GREY HOUSE PRECINCT,  
PYMBLE LADIES' COLLEGE

SSD-17424905

Architectural Design Report  
Addendum

05. 04. 22

3 SHADOW DIAGRAM PROPOSED June 21 - 2PM
1 : 1000

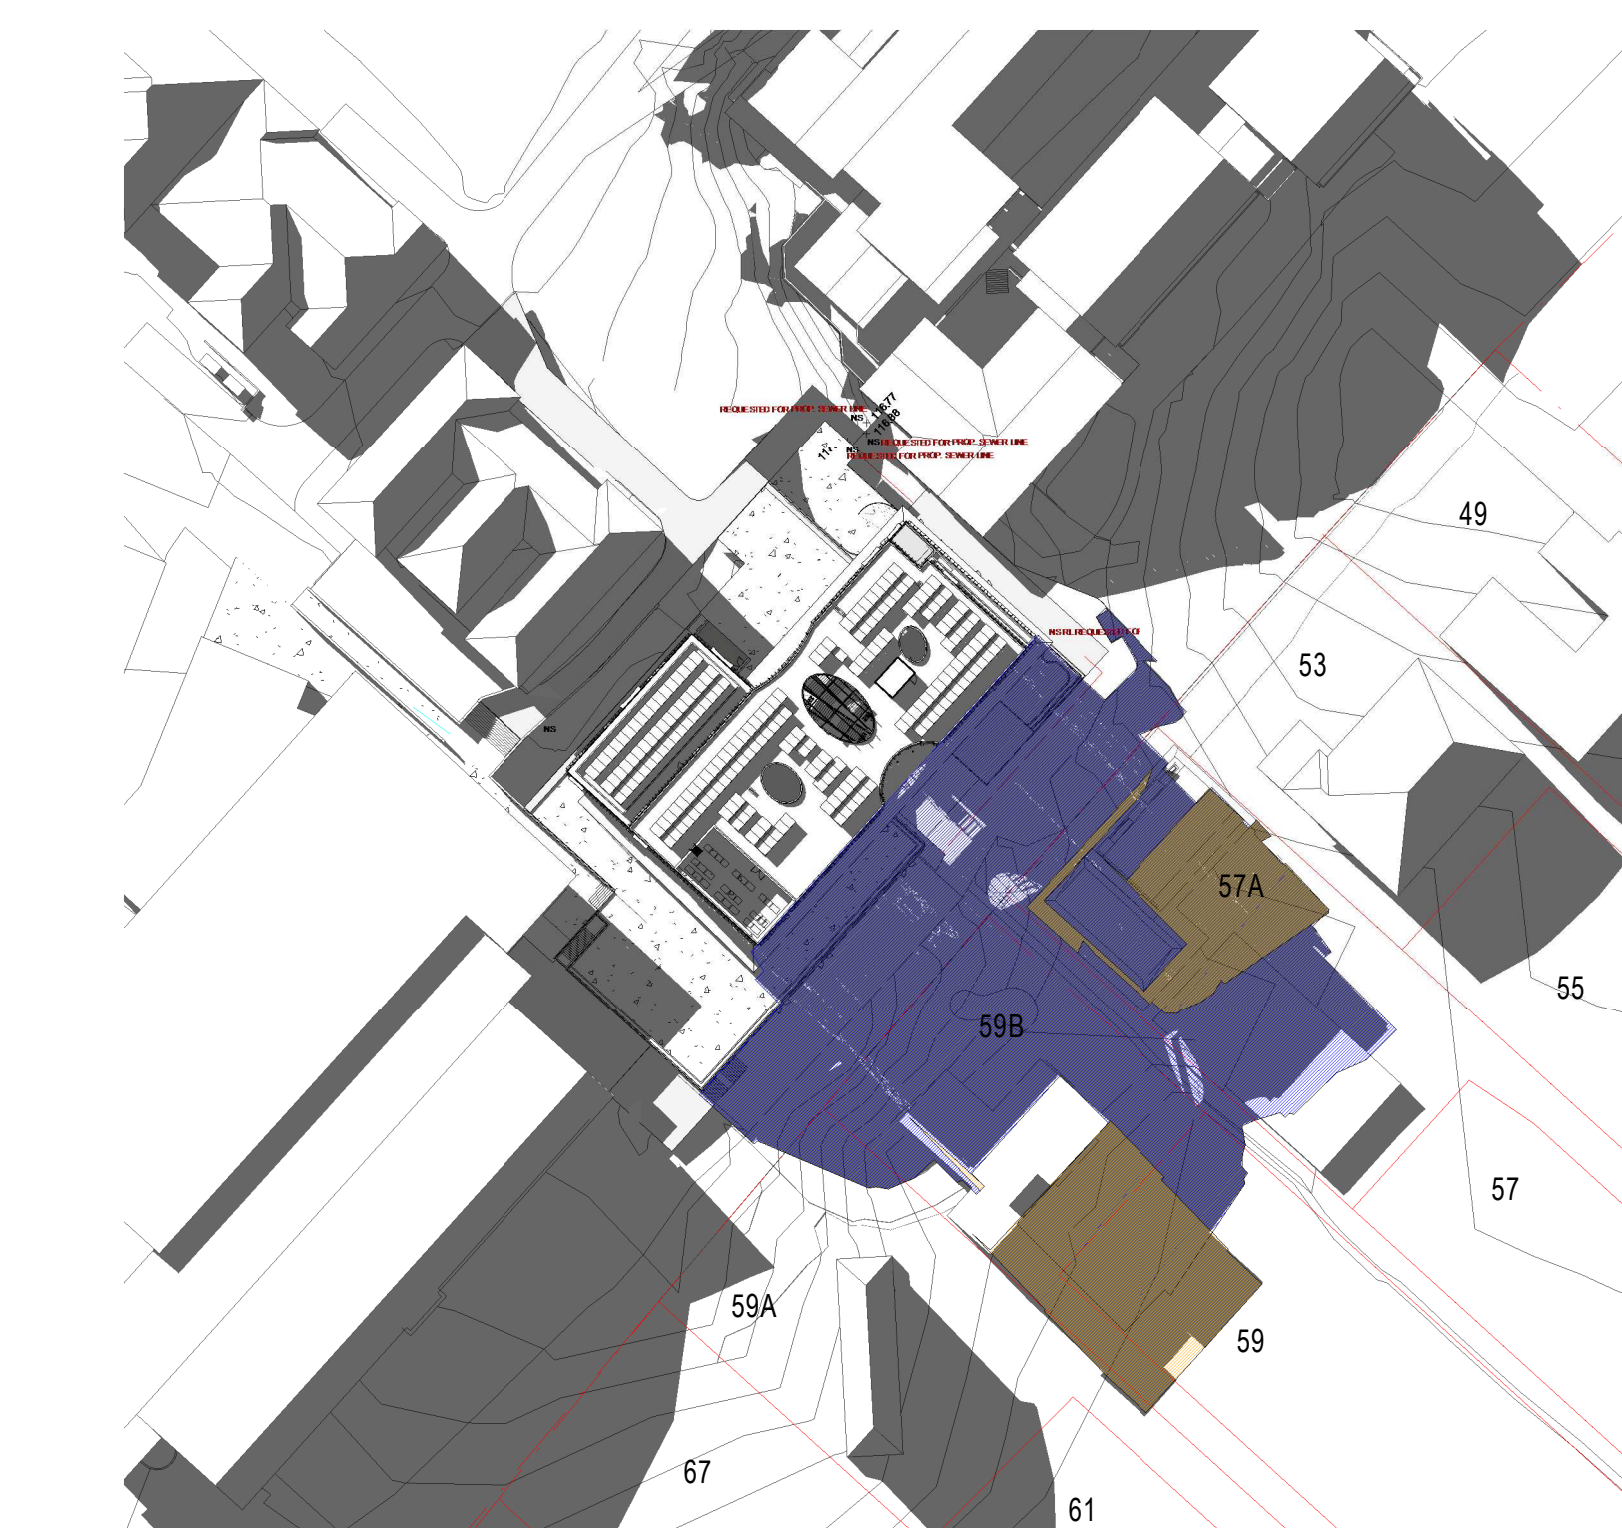
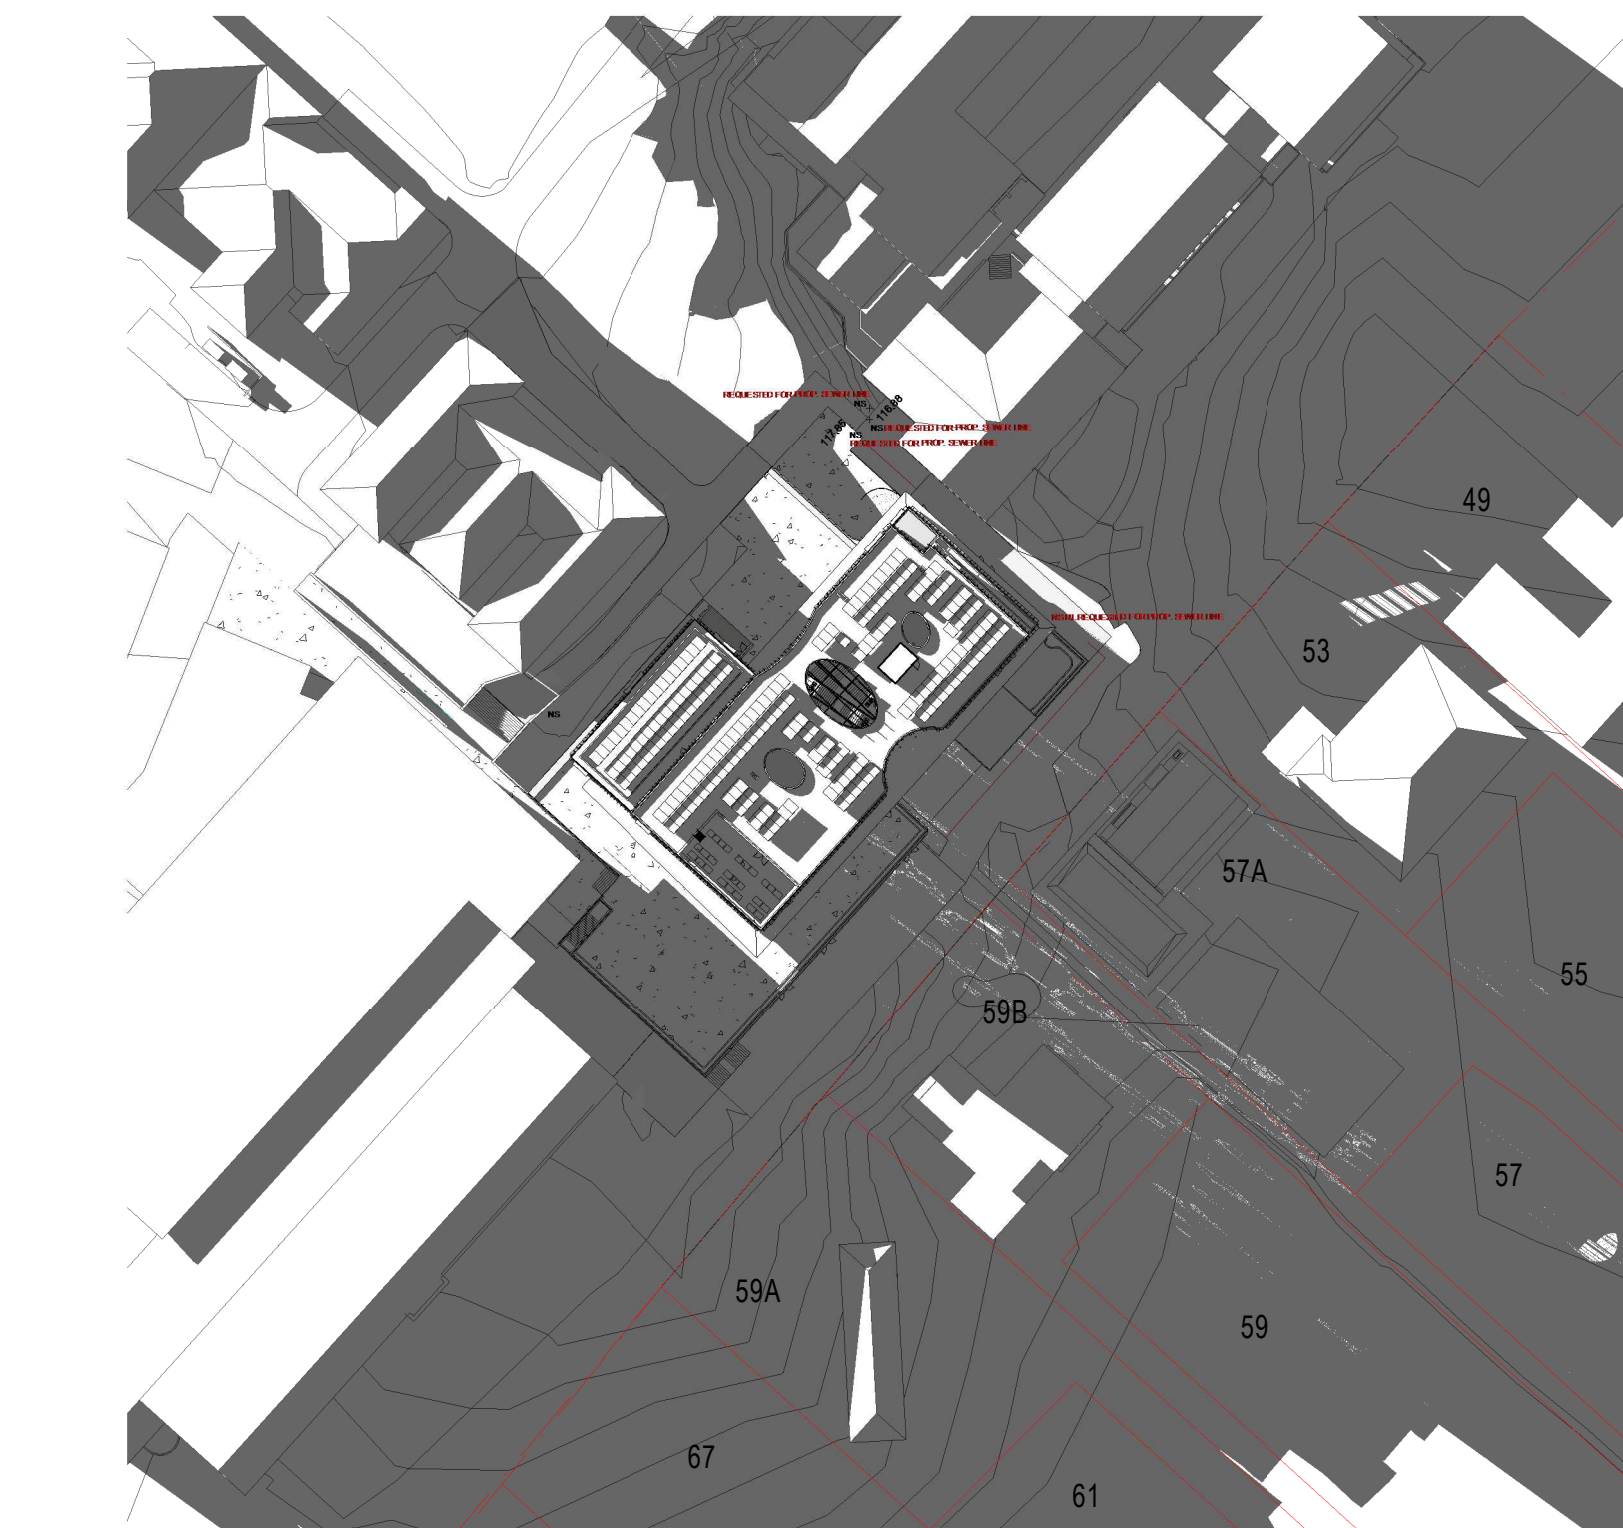
11. Clarify the impact of the proposal on the solar access of the adjoining properties, as this has not been clearly demonstrated. Provide existing and proposed diagrams identifying the quantum of solar access to the living area glazing and the principal private open space of affected properties to demonstrate if a reasonable level of solar access will be maintained for the adjoining properties.

This report includes solar access analysis of the impact of the Grey House Precinct to the adjoining residential properties.

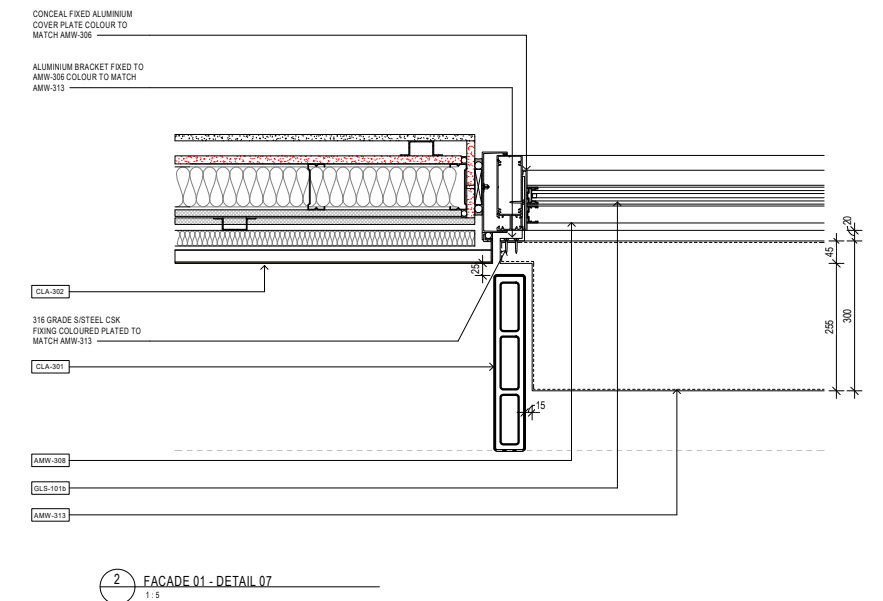
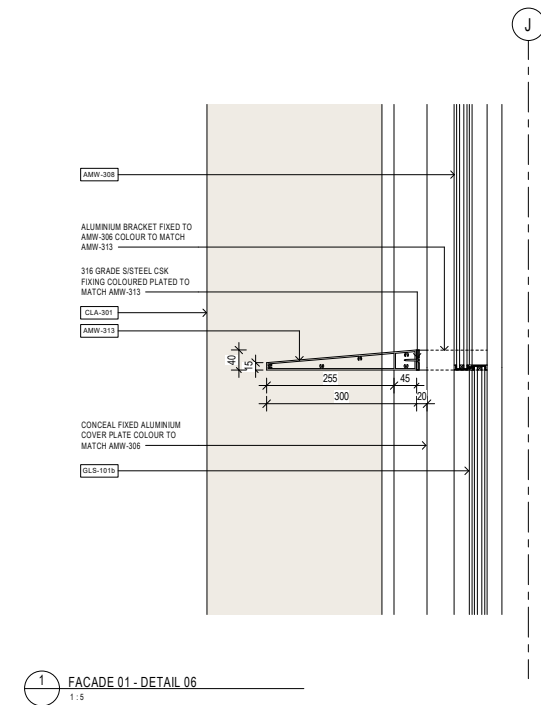
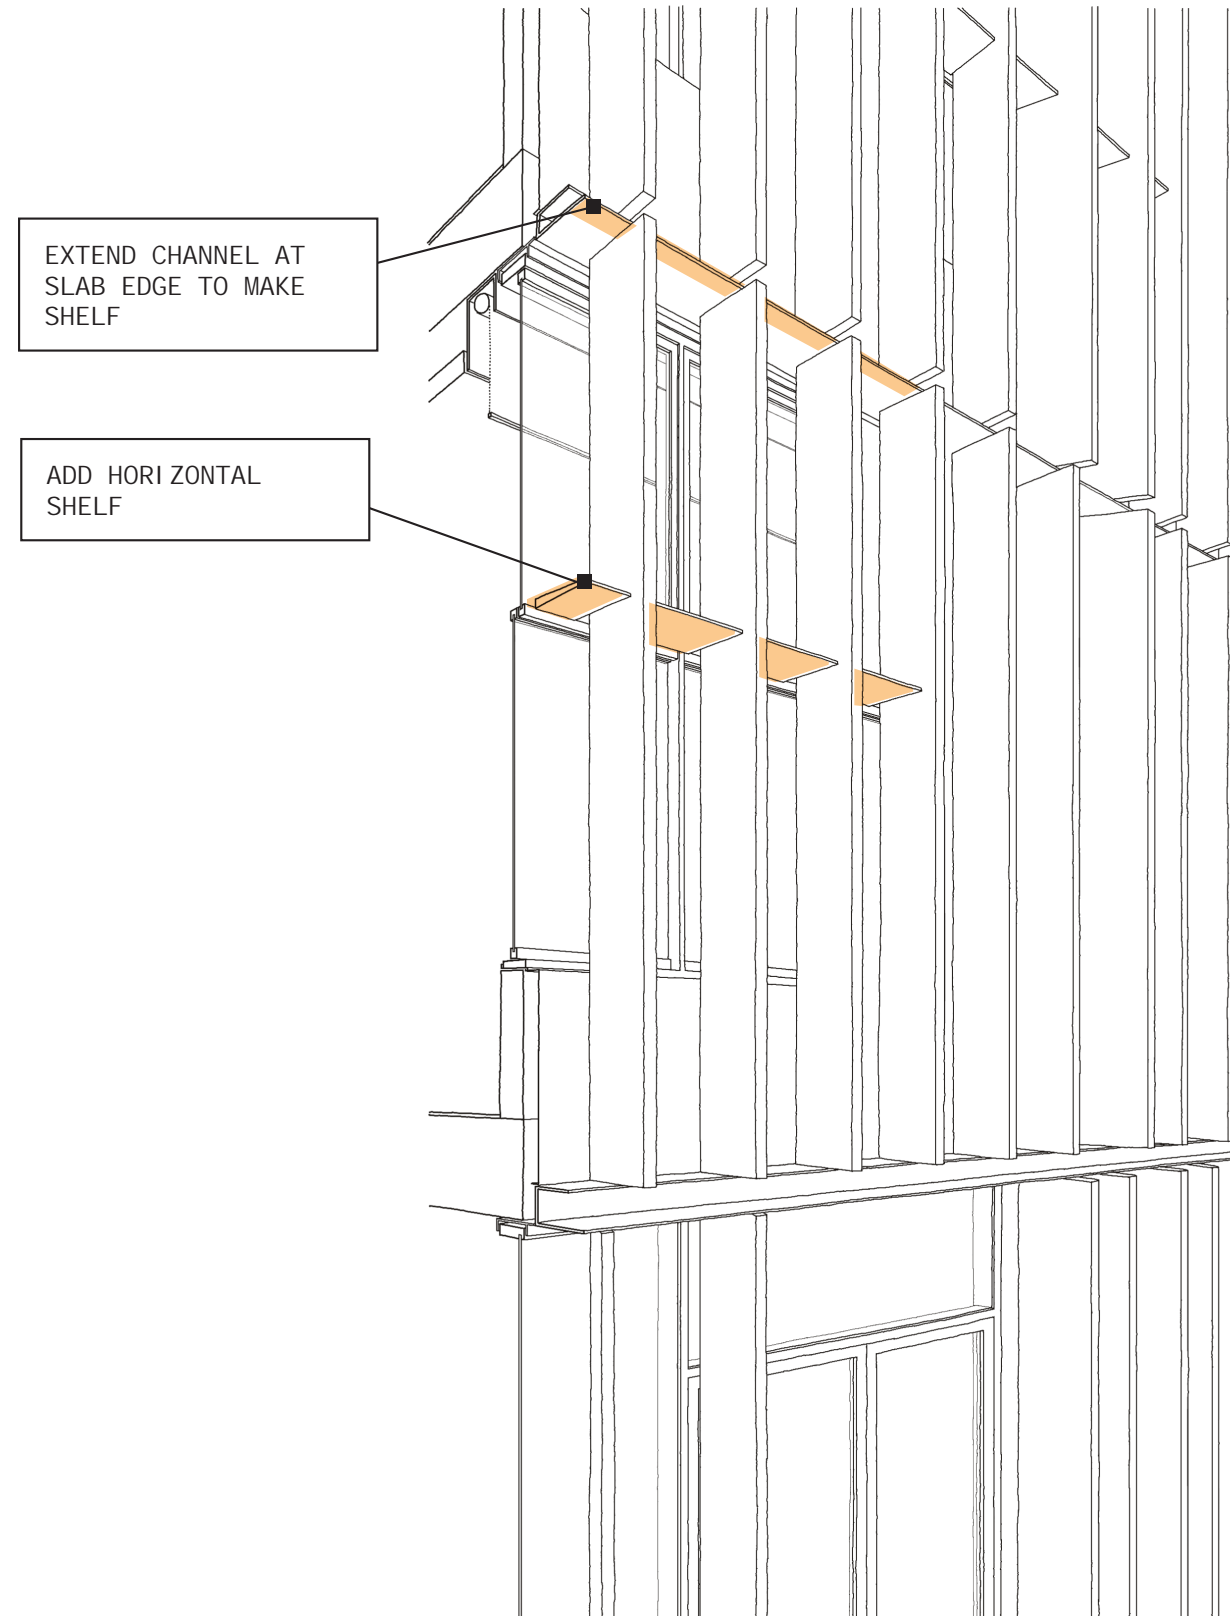
4. The proposed glazing treatment should be complimented with more horizontal shading strategies to improve daylight and enable access to natural ventilation.

New horizontal elements have been introduced to break the verticality of the fins, increase shading and frame views towards neighbouring properties. The changes adopted include:

Extension of channel at slab edge  
Horizontal shading added at 1625mm above FFL increasing the depth of picture windows, from 670mm to 1000mm.
